TALASAEA
CONSULTANTS, INC.

Ms. Nicole Gaudette
Senior Planner
City of Mercer Island Development Services Group
9611 SE 36th Street
Mercer Island, Washington 98040

REFERENCE: Review Comments for File No. CAO17-010 – Hou Critical Areas Determination 4825 E Mercer Way, Mercer Island, WA 98040; King County Tax Parcel #216200-0070

SUBJECT: Response to City of Mercer Island Comments dated 11 July 2018

Revisions	By	Date
Date	7-21-2017	
Scale	1"=20'	
Designed	AQ	
Drawn	MW	
Checked	OA	
Approved	ES	
Project	#1124B	
Sheet #	W11

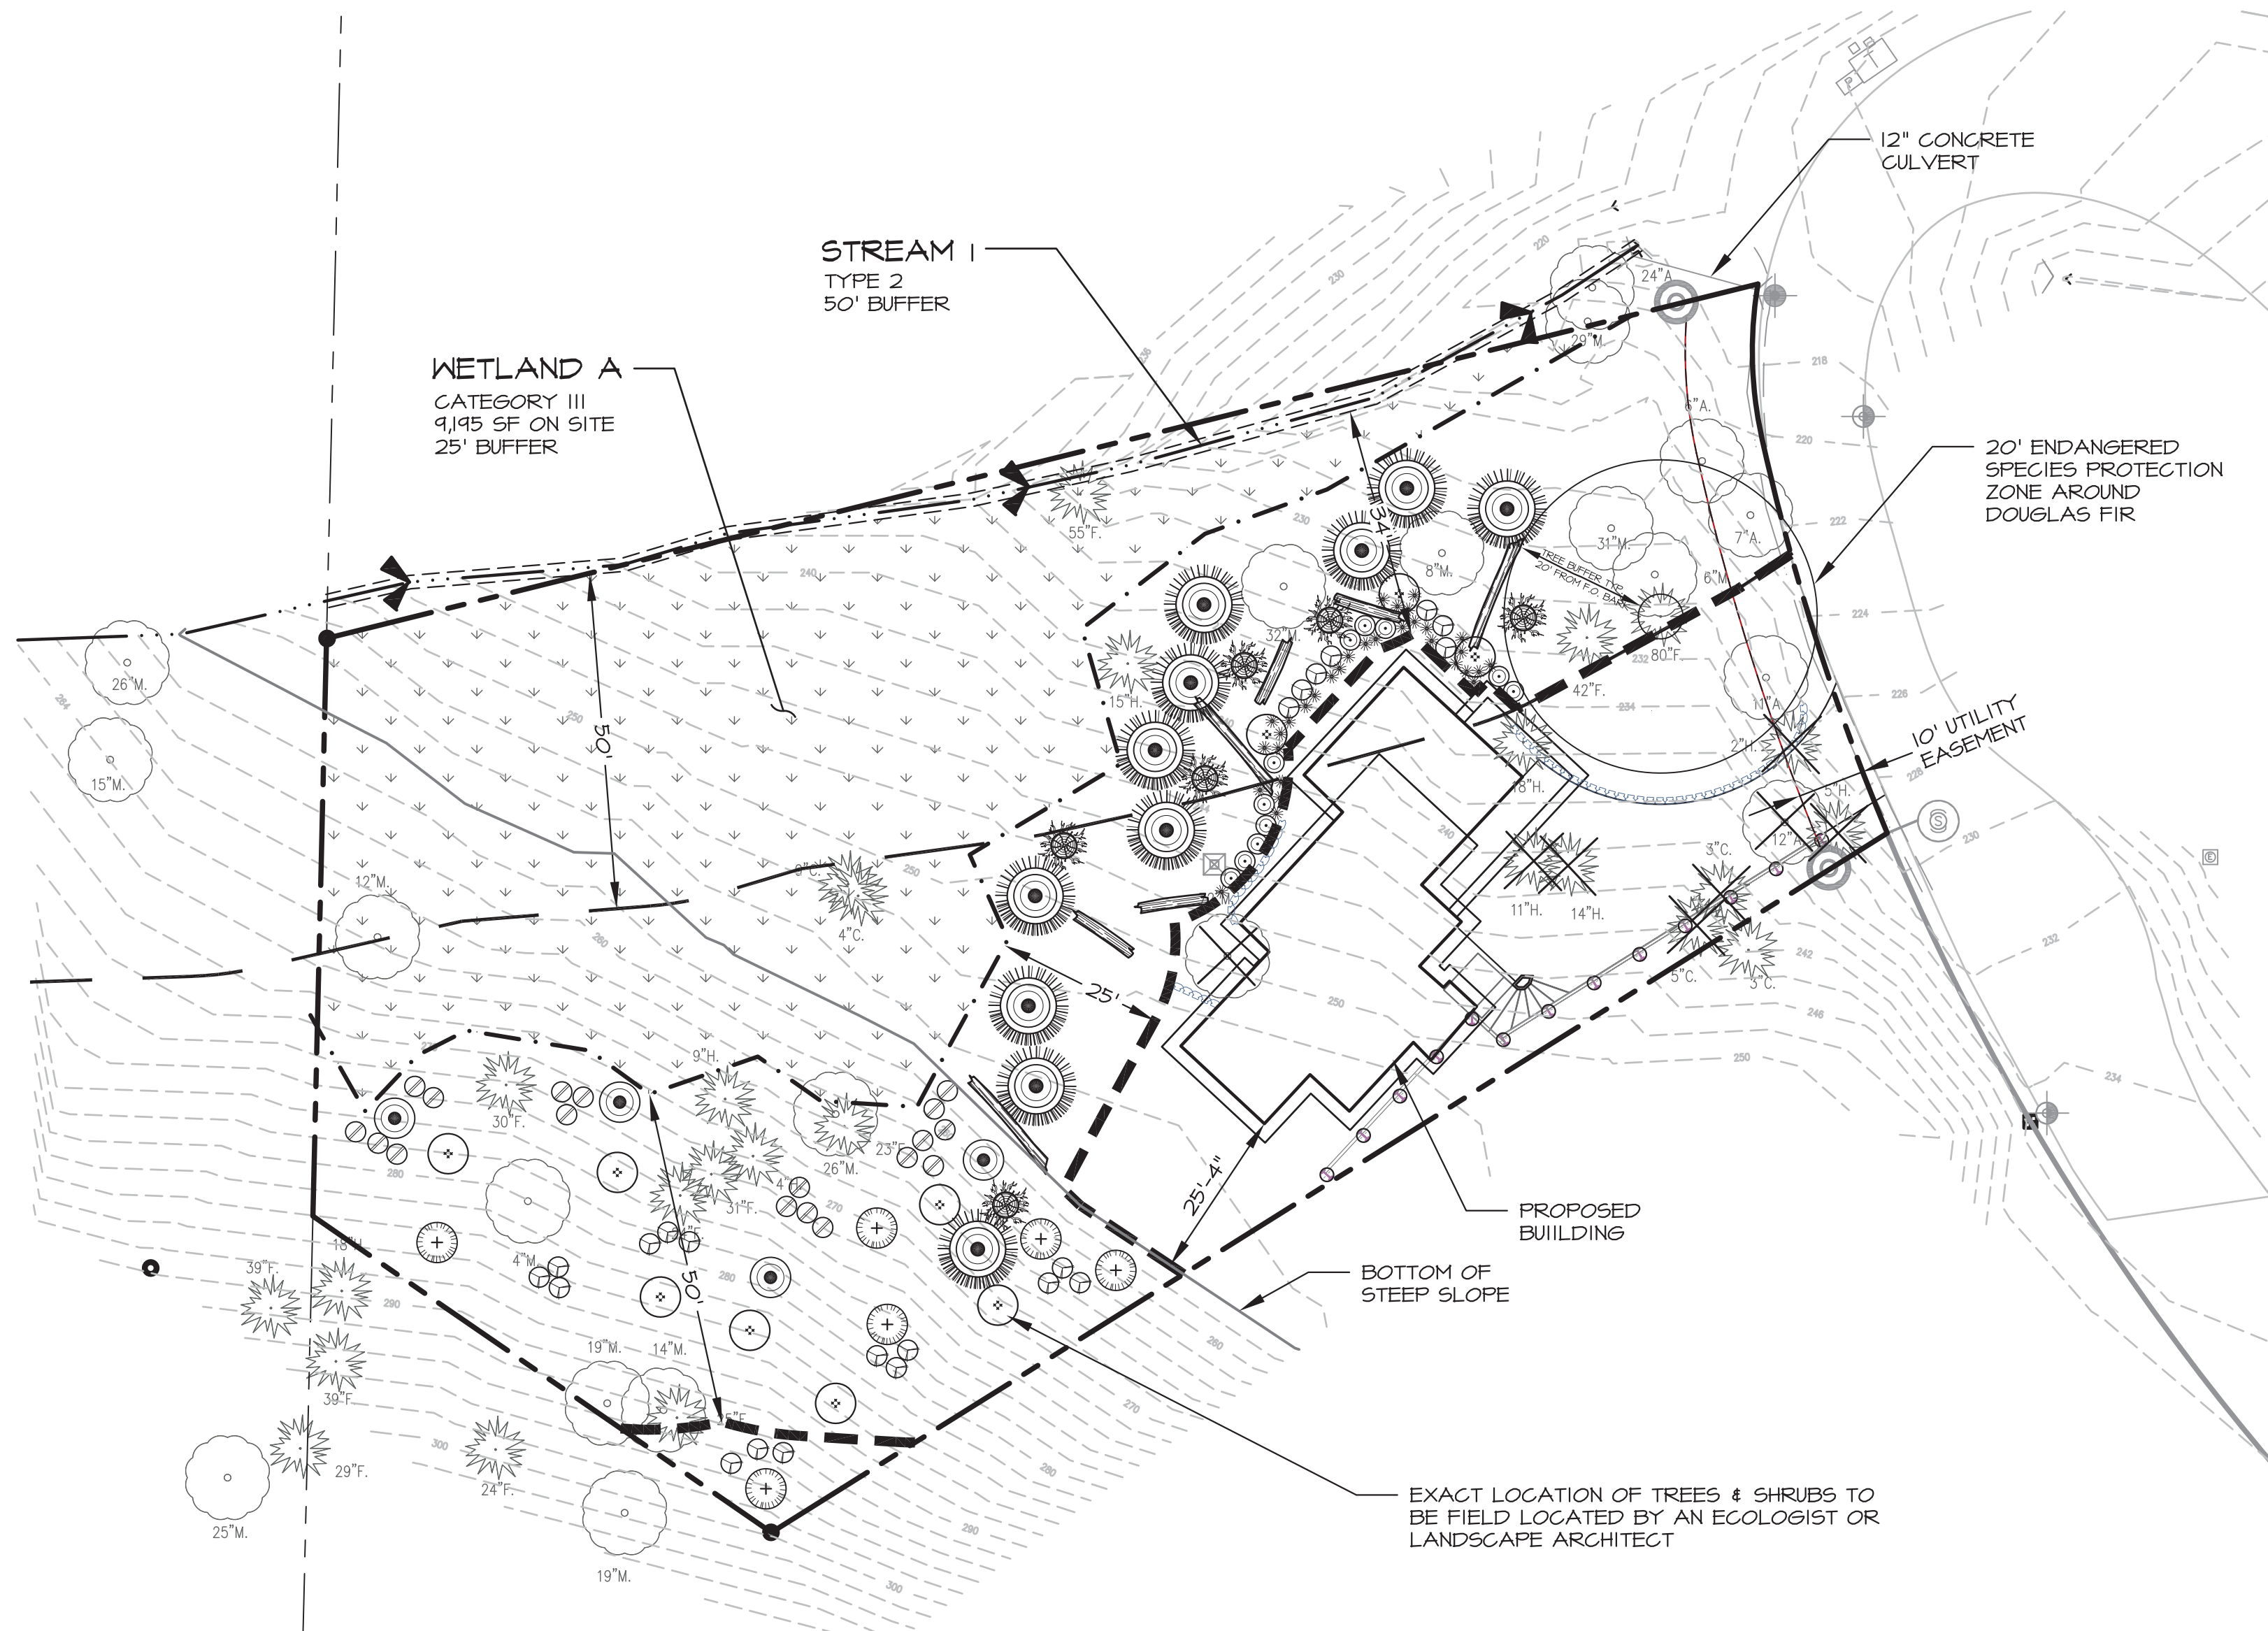
- 3. According to MICC 19.07.070.b(3)(c) the total area contained in the averaged buffers cannot be decreased below the total area that would be provided if the maximum width were not averaged. The legend on Sheet W1.1 of the mitigation plan indicates that area of stream buffer reduction is 354 square feet and the area of stream buffer replacement is 333 square feet. Since the area of stream buffer reduction is more than that area of buffer replacement the mitigation plan is not in compliance with code requirements. In addition, the stream buffer replacement area proposed is not contiguous with the stream itself and therefore does not contribute to function and values. Instead, the area of stream buffer replacement is located within the buffer of Wetland A and likely provides benefits to the wetland's buffer. Please provide stream buffer replacement contiguous to the stream.**

By	
Date	9-4-2018 KM
Revisions	
CITY COMMENTS	
Date	7-27-2017
Scale	1"=20'
Designed	AQ
Drawn	MW
Checked	OA
Approved	ES
Project #	#1124B
Sheet #	W11

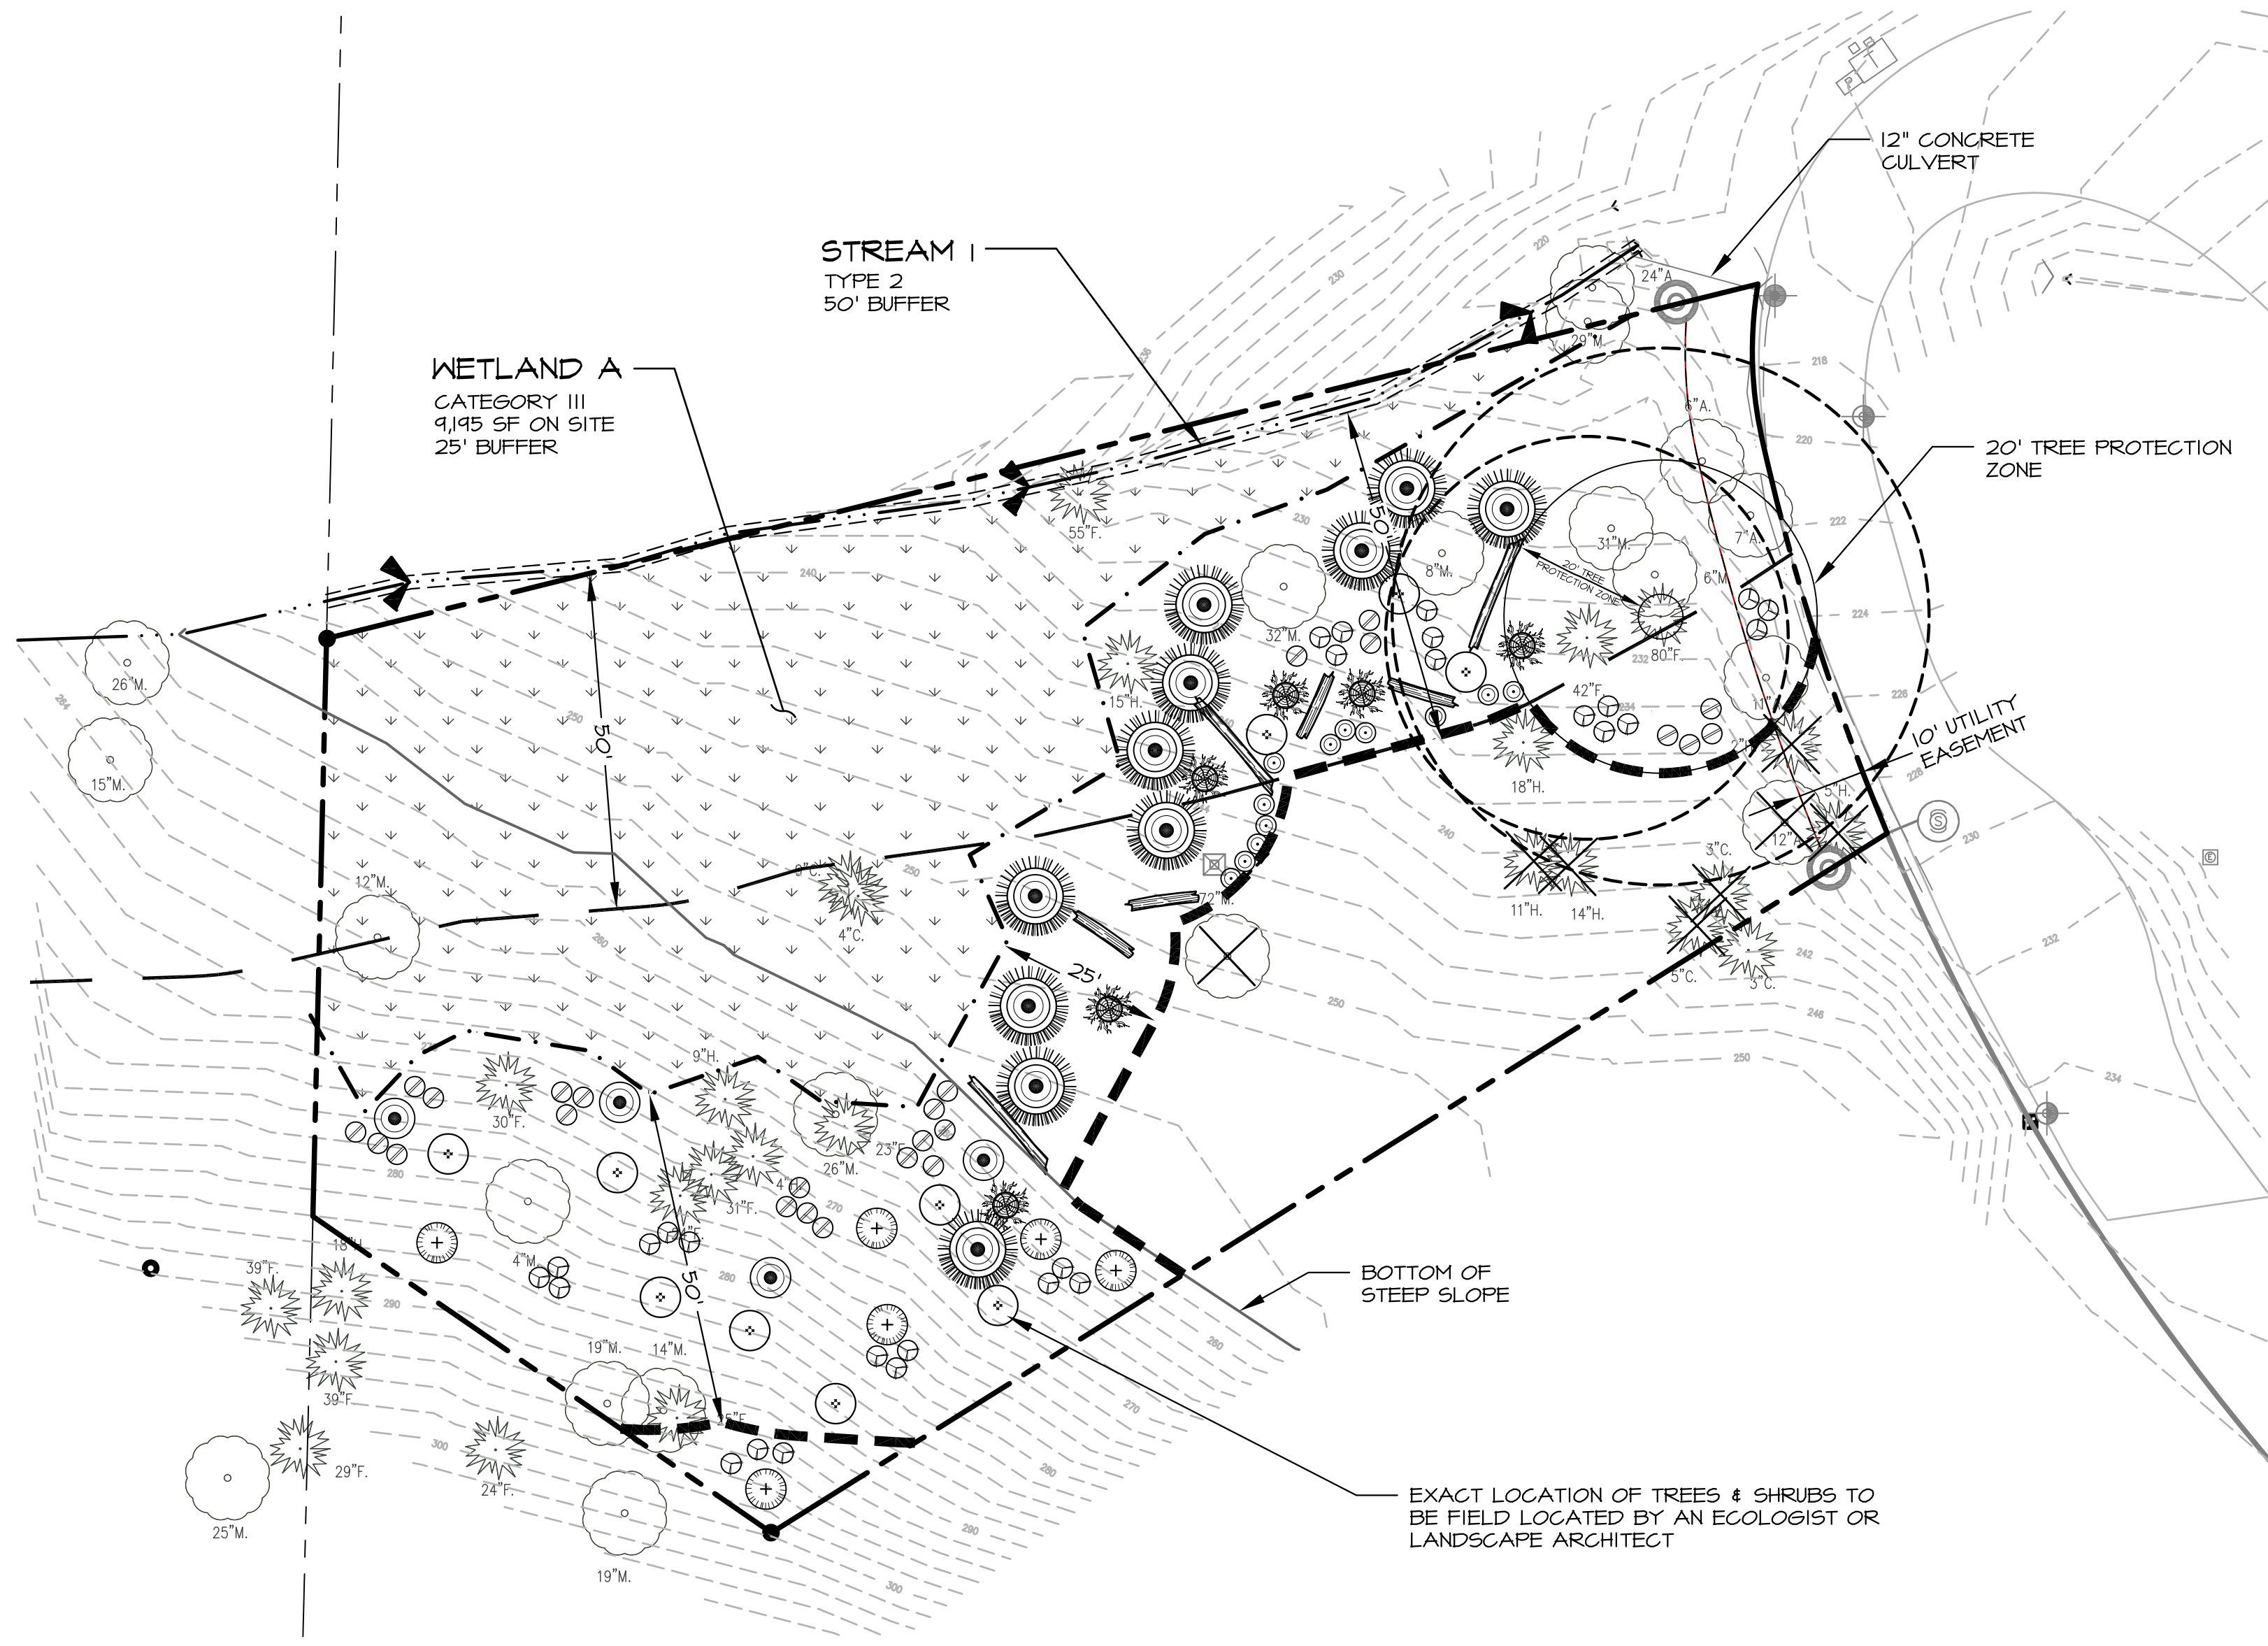
- 4. The proposed woody shrub plantings in the eastern portion of the buffer enhancement area for stream buffer reduction mitigation will be planted approximately 34 feet from Stream 1 at the southern edge of the buffer, bordering the proposed house. The placement of woody shrub plantings at this distance will not significantly contribute to improving stream functions. In addition, proposed plantings for the remaining portions of the buffer enhancement area are sparse and limited in number. ESA does not believe that the proposed buffer enhancement would provide adequate mitigation for impacts from buffer averaging, as these features would not significantly improve ecological functions of the stream.**

- 6. The wetland and watercourse buffers shall not be reduced within the drip lines of trees 916 and 917 which provide habitat benefits (e.g. shading, organic inputs, etc.) to the wetland and watercourse. Please add the drip lines of these trees to the plan sheets.**

The Proposed Site Development Plan has been revised to reflect NO modifications to the stream buffer (**Attachment 2**).

The Proposed Site Development Plan has been revised to reflect NO modifications to the stream buffer.

Please provide the language from the MICC that stipulates buffer reductions relative to drip lines of trees. The drip lines of the two trees have been added to the Proposed Site Development Plan for clarity. Reductions to the stream buffer have been removed from the Plan, which includes removing additional proposed development from within the dripline of these two trees. However, wetland buffer reduction is still proposed with a minor area of reduction occurring within the drip lines of concern. This area is a small fragment of the total drip line of these two trees. The previously stipulated 20-foot tree protection zone remains around the larger of the trees. A summary of drip line encroachments is below in **Table 1**. Total tree removal on the Site is 25% (8 out of 32 trees) with a 75% retention rate.
